# CITY OF ALBUQUERQUE

**Re: West Mesa Ridge Apartments**  
**701 Coors Blvd NW, Albuquerque NM 87121**  
**Traffic Circulation Layout**  
Engineer's/Architect's Stamp 05-29-24 (J11D048)

Based upon the information provided in your submittal received 06-12-24, the above referenced plan cannot be approved for Building Permit until the following comments are addressed:

TCL1.0

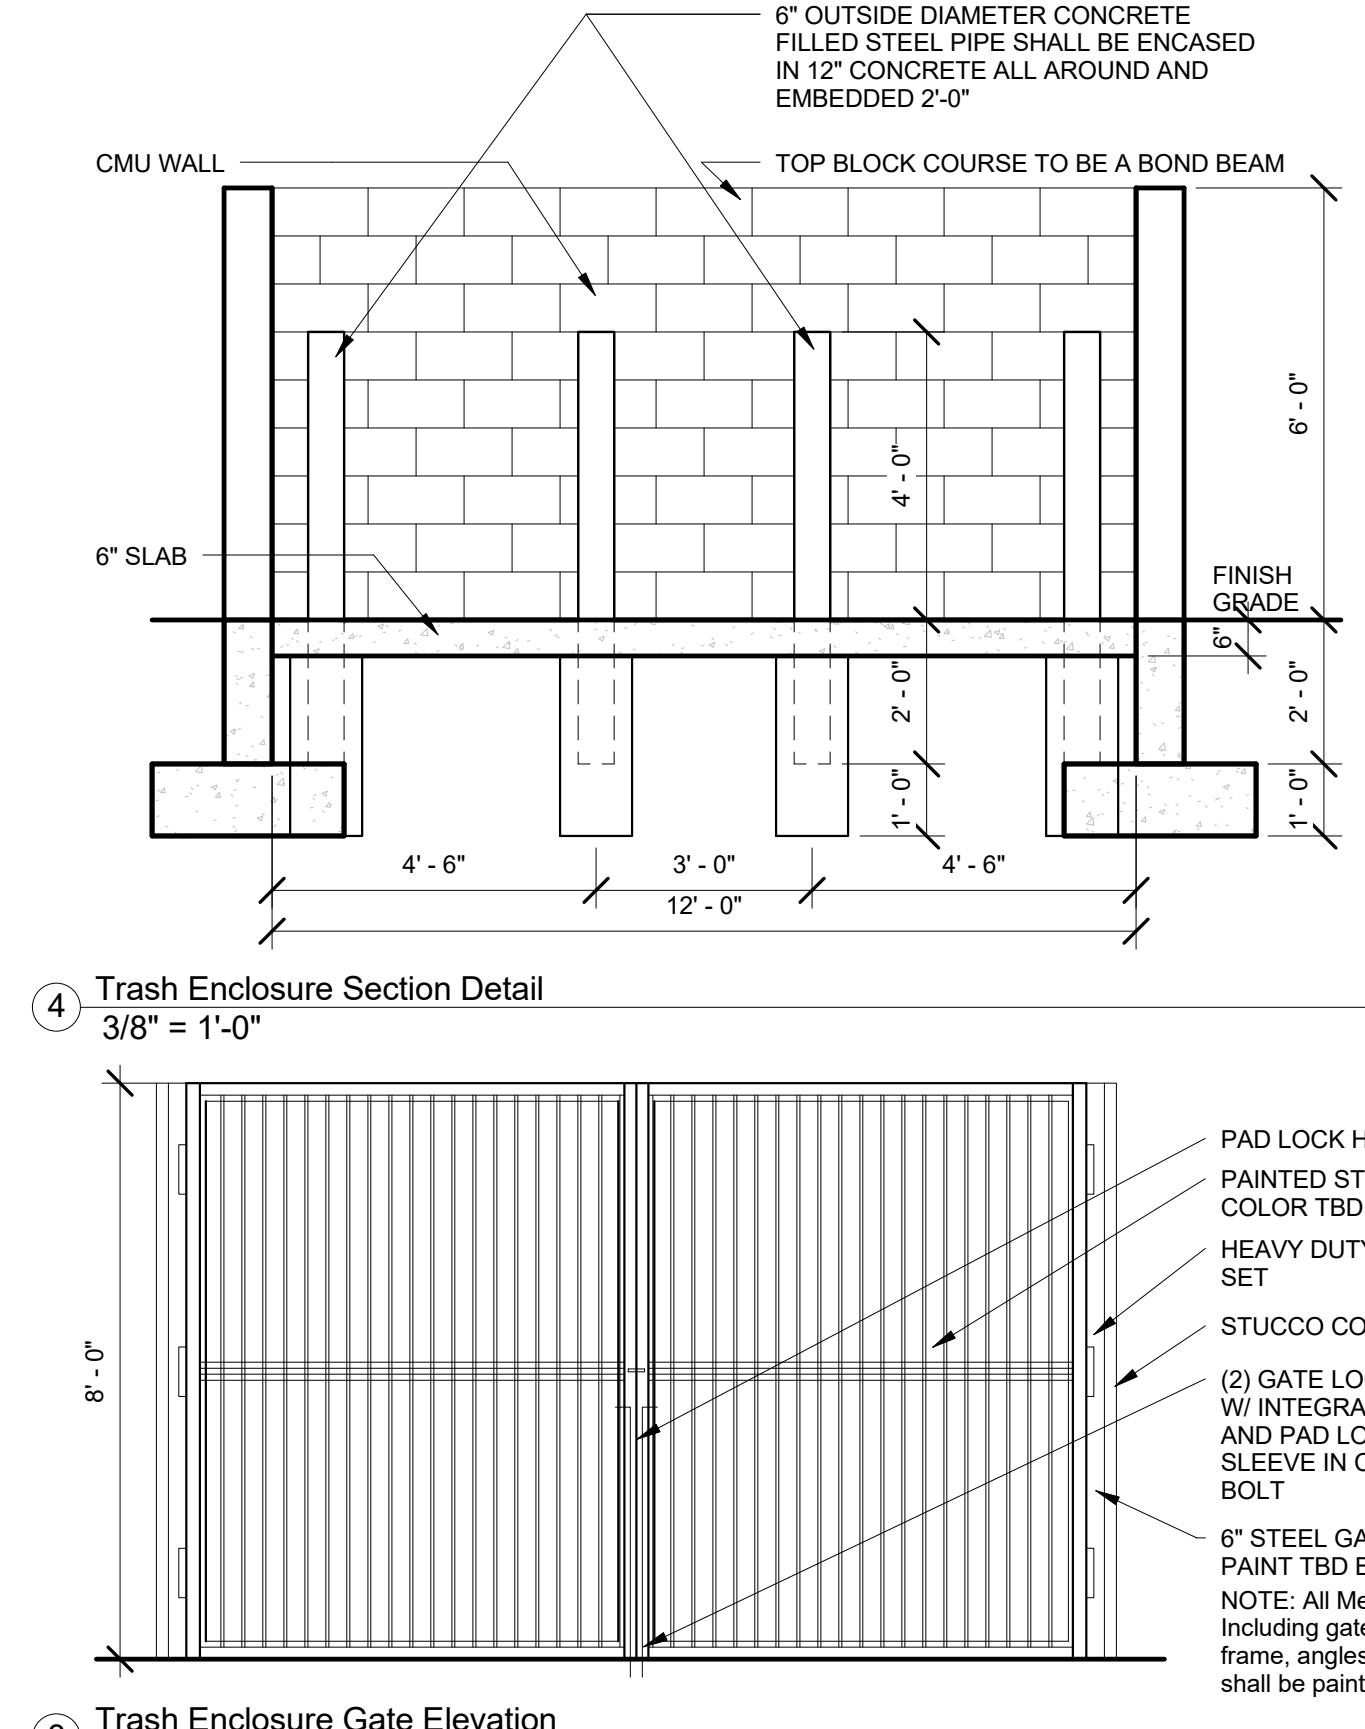
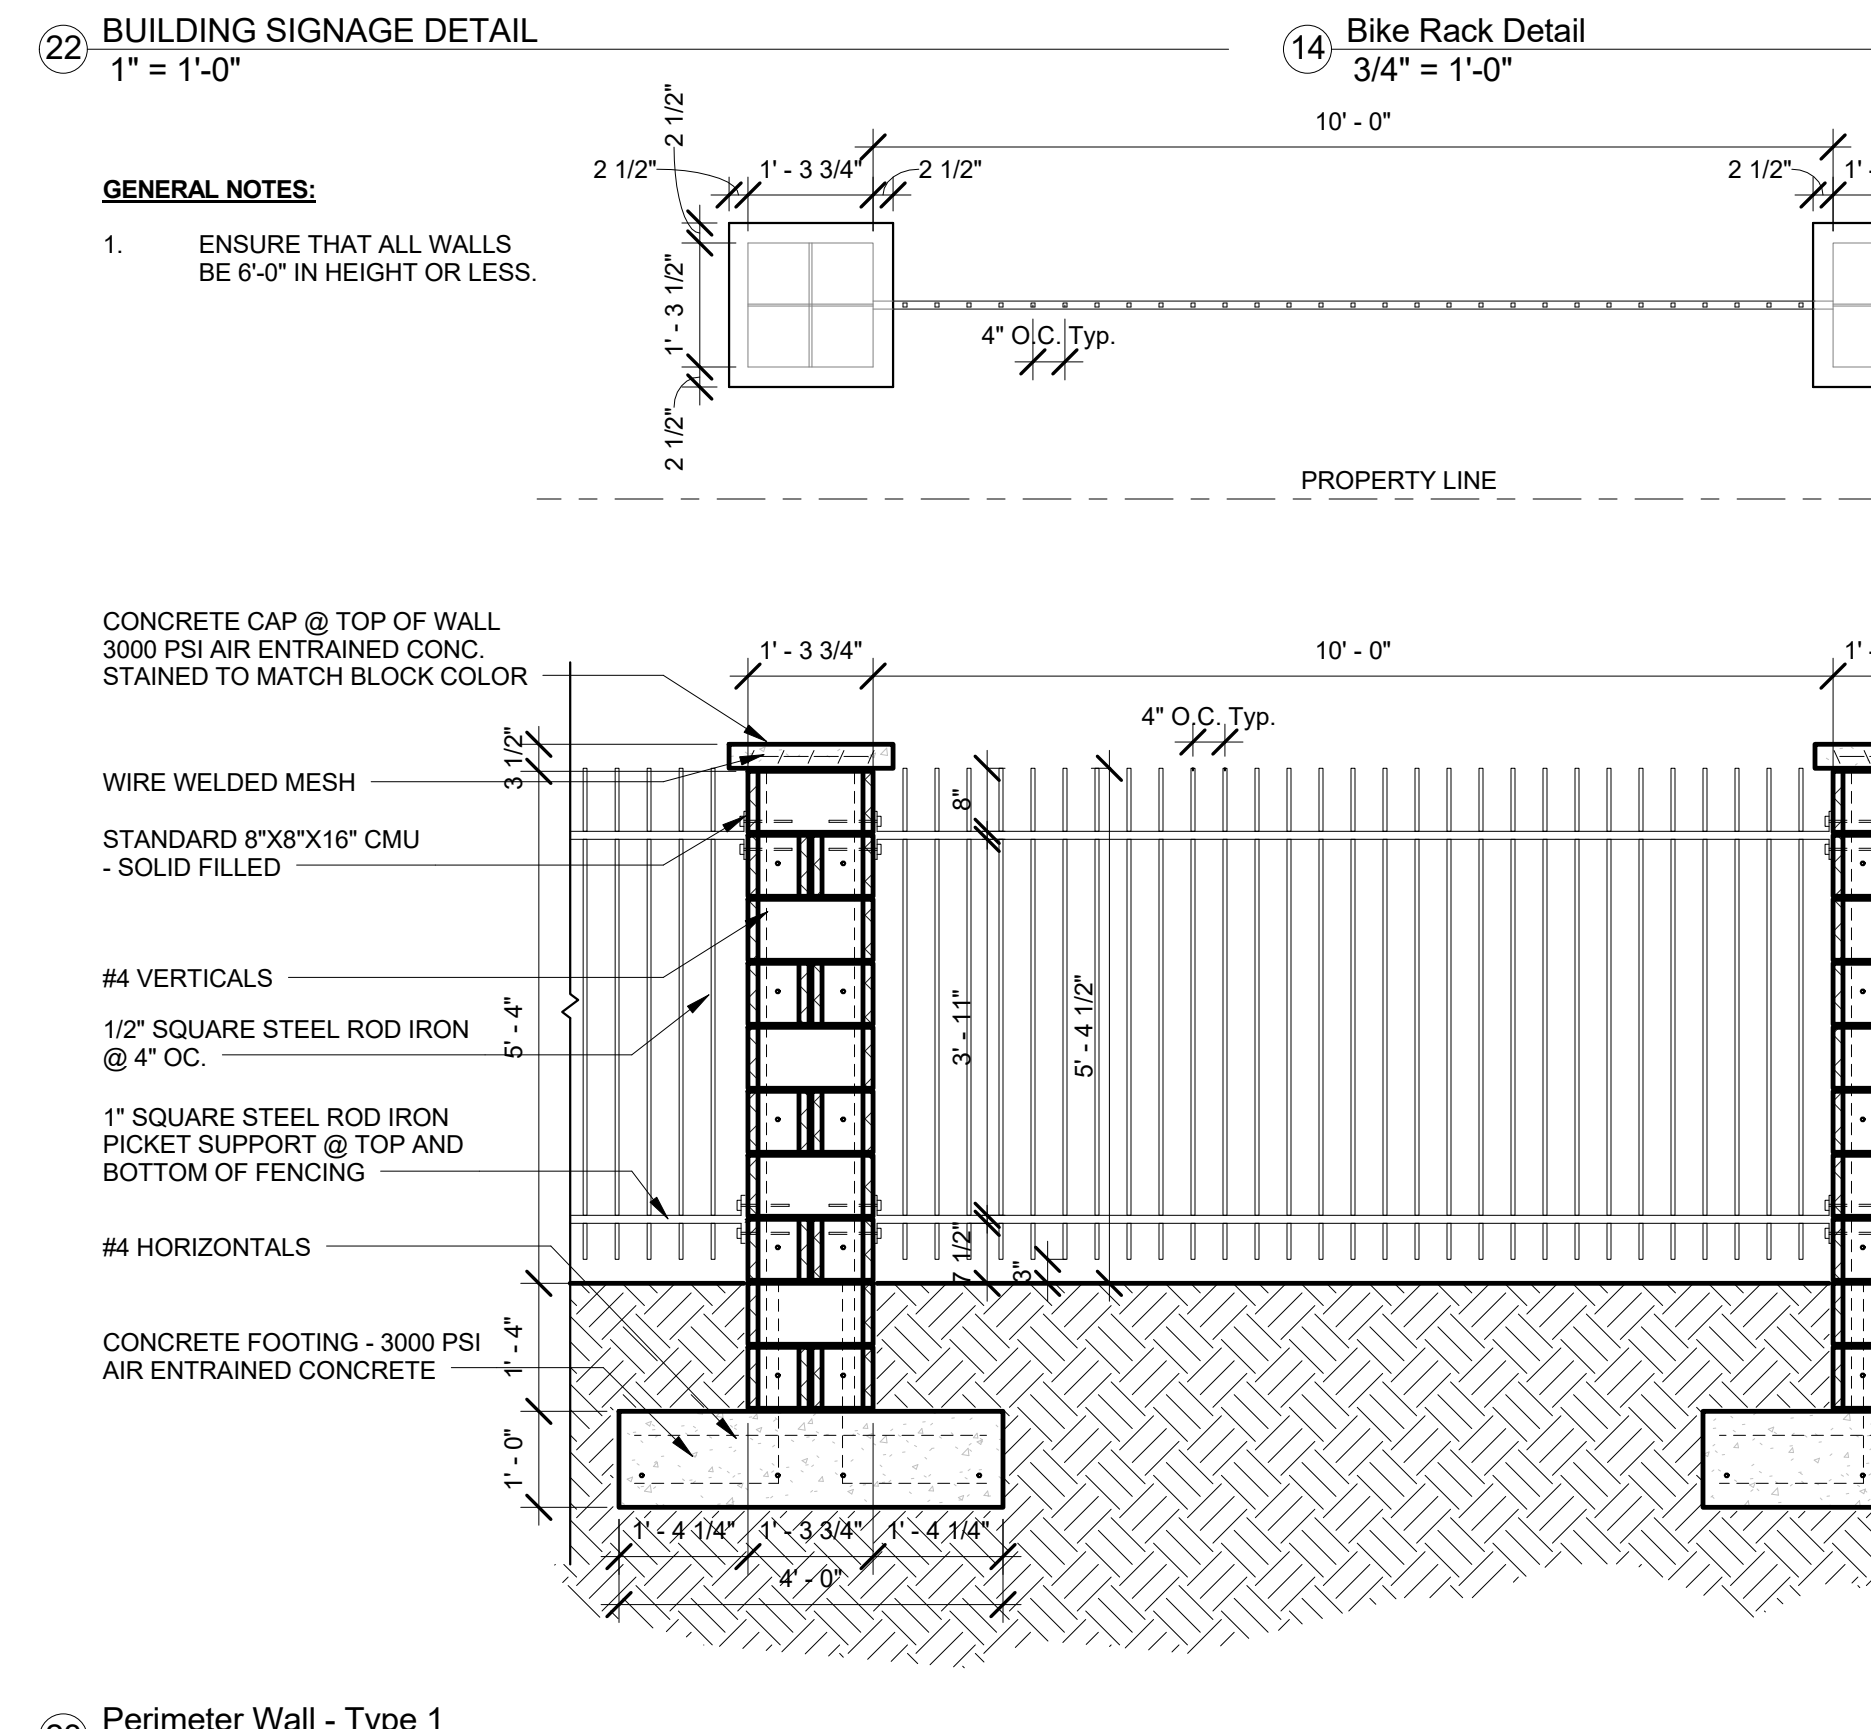
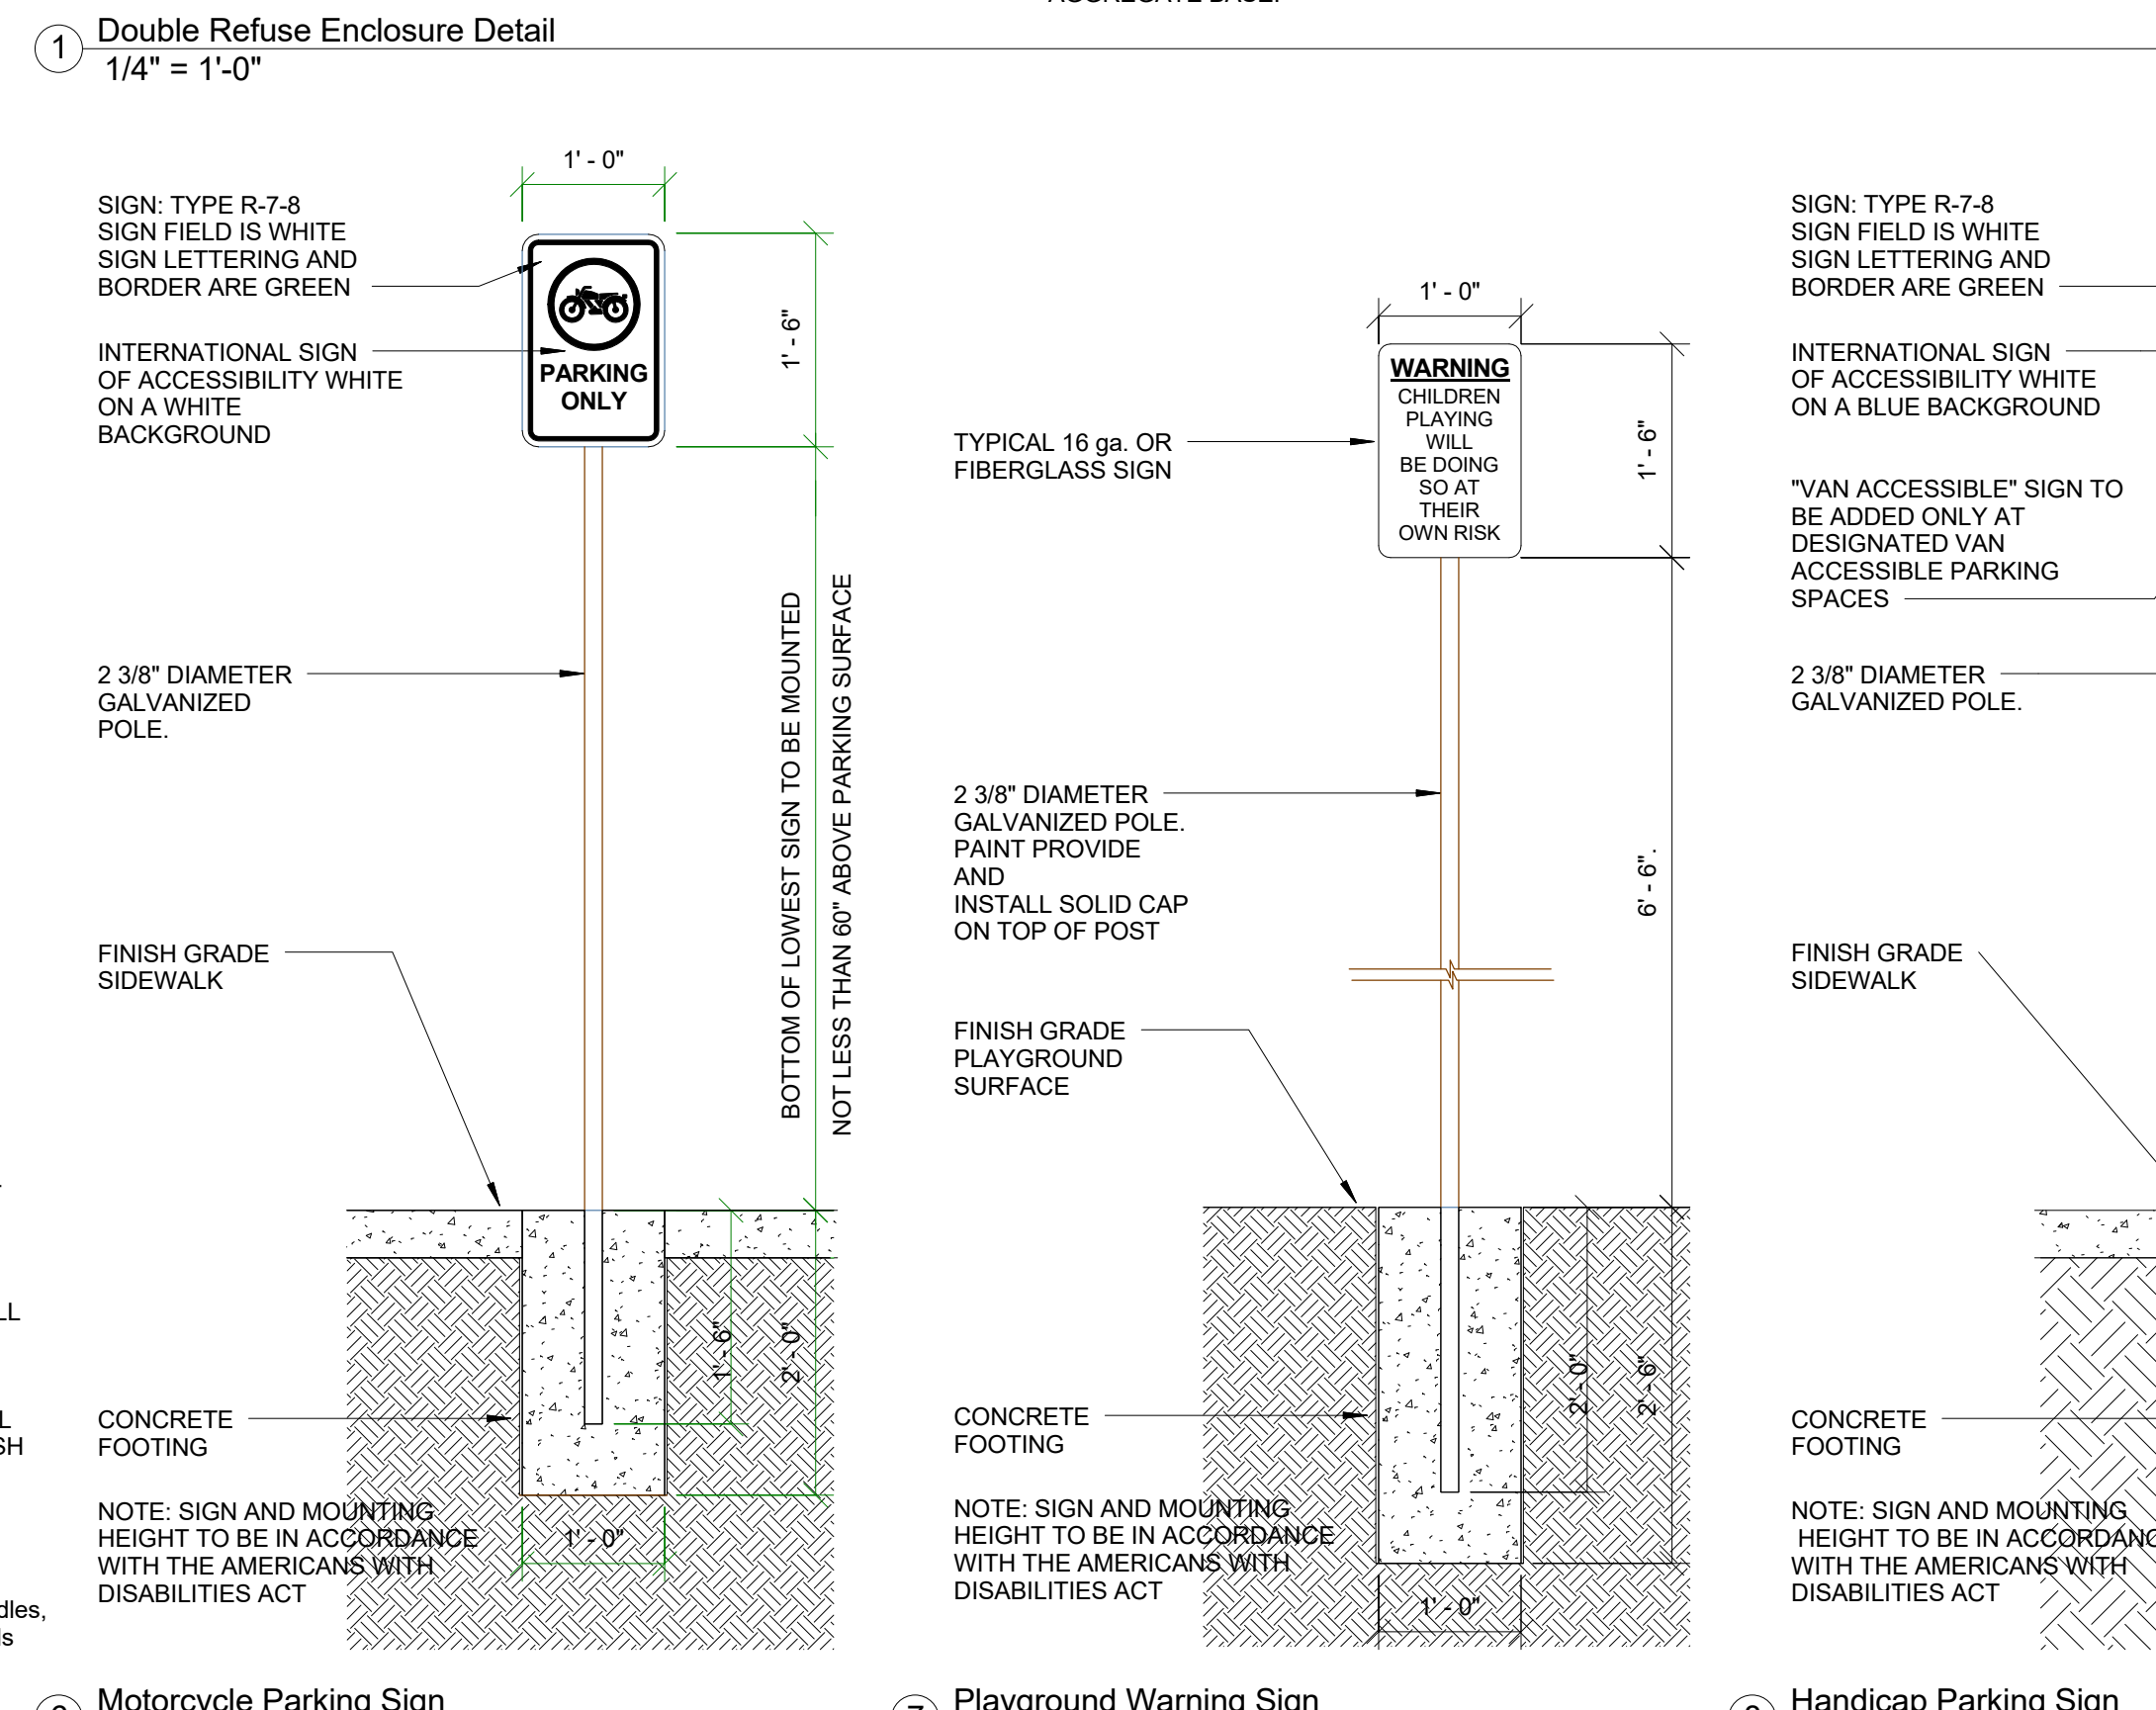
1. Provide an approved infrastructure list.
2. Show the location/details of main entrance to the facility.
3. Provide the agreement from the adjacent property owner since you will be using the highlighted area for construction work.

4. Provide the sidewalk easement for this corner: Also, ADA curb ramps must be constructed as per current standards and have truncated domes installed.

5. Provide the hatch legends
6. Show the number of spots for motorcycle parking and bike racks required by IDO in the plan.
7. Please identify all existing buildings, doors, structures, sidewalks, curbs, drive pads, wall and anything that influences the parking and circulation on the site.
8. Identify all existing access easements and rights of way width dimensions.
9. Identify the right of way width, medians, curb cuts, and street widths on Street(s) Name.
10. Provide the width of the site access/entrance. Maximum access width for arterial, collector, and local streets are as follows:

11. Show existing driveways on the adjacent properties and properties across the street from the site. Indicate distancing from these existing driveways to nearby
12. Show all drive aisle widths and radii. Some dimensions are not shown.
13. The minimum drive aisle dimensions are shown below

14. List radii for all curves shown; for passenger vehicles. Radius for delivery trucks, fire trucks, etc. is 25 ft. or larger.
15. Provide dimensions:
